CITY OF ALBUQUERQUE

March 11, 2019

RE: Hope Christian School – Elementary
6721 Palomas Ave. NE
Grading and Drainage Plan
Engineer's Stamp Date: 02/21/19
Hydrology File: D18D009A

Based upon the information provided in your submittal received 02/22/2019, the Conceptual Grading Plan and Drainage Report **is not** approved for action by the DRB for Site Plan for Building Permit. The following comments need to be addressed for approval of the above referenced project:

CD-2

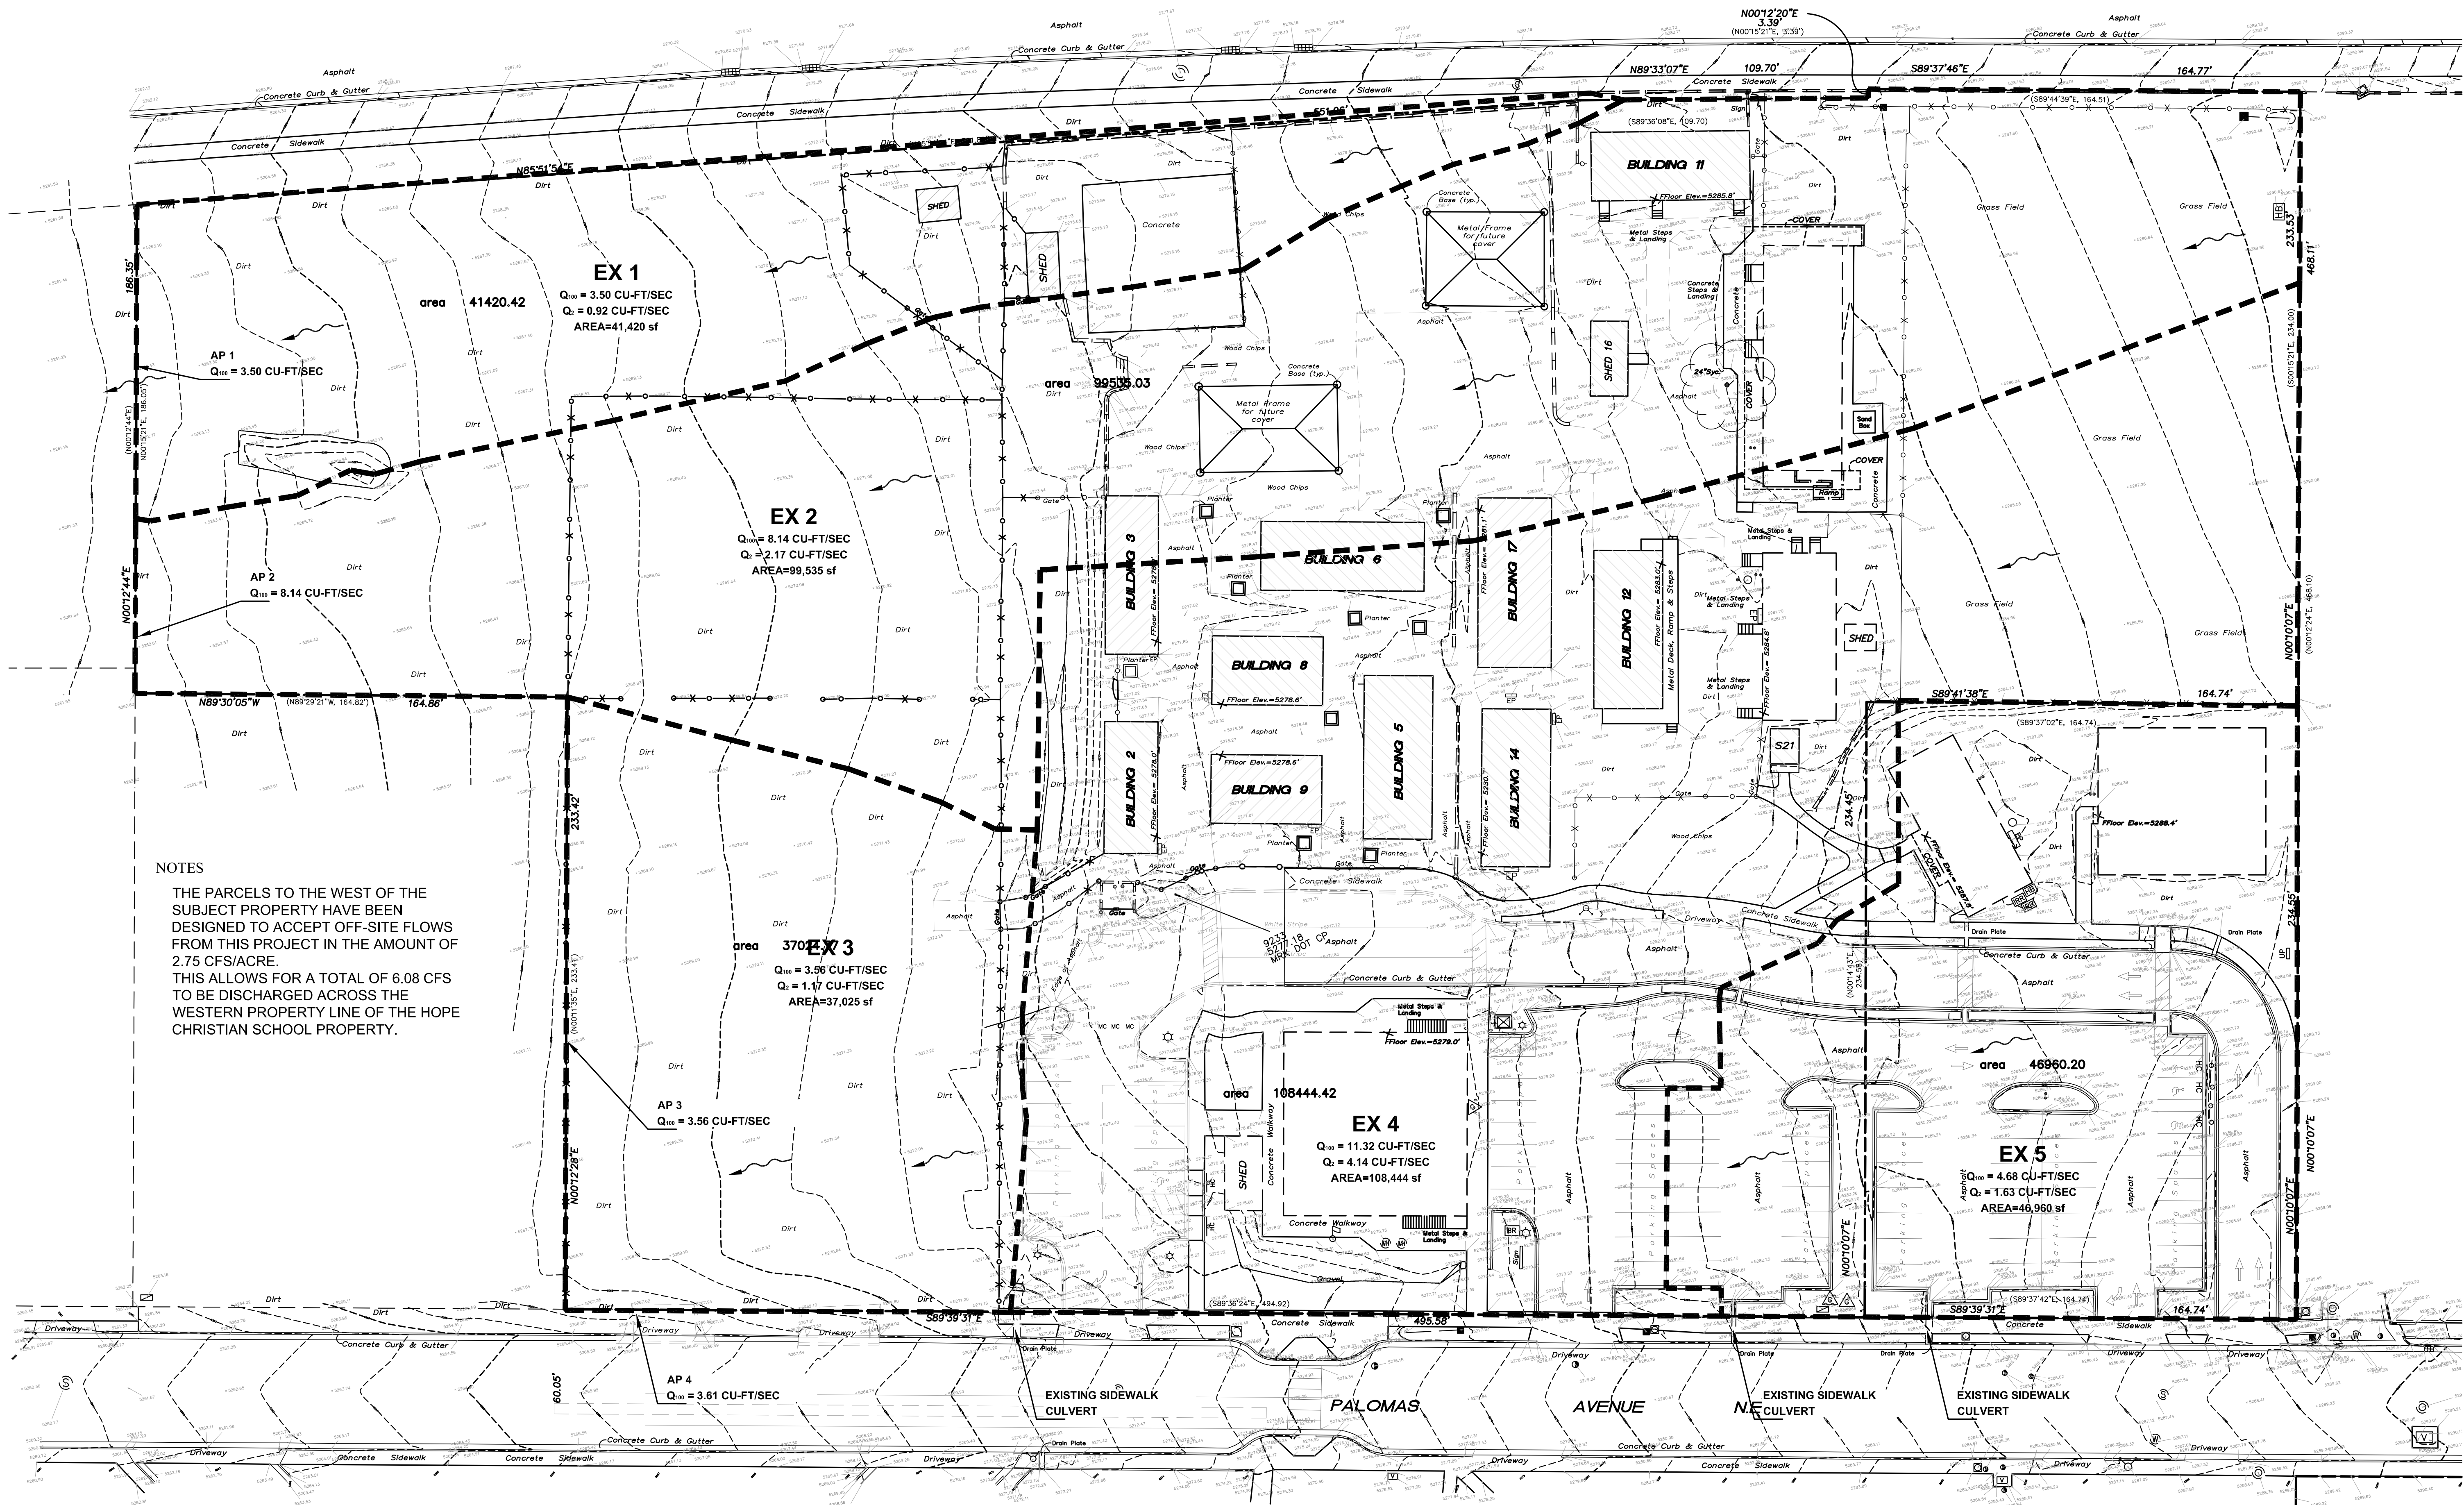
8. Sheet CD-2. Please fix Drainage Areas EX3 and EX4 to show the existing paving draining through the existing sidewalk culvert in Drainage Area EX4.
9. Sheet C-203. Please add some flowline information within the proposed parking lot.
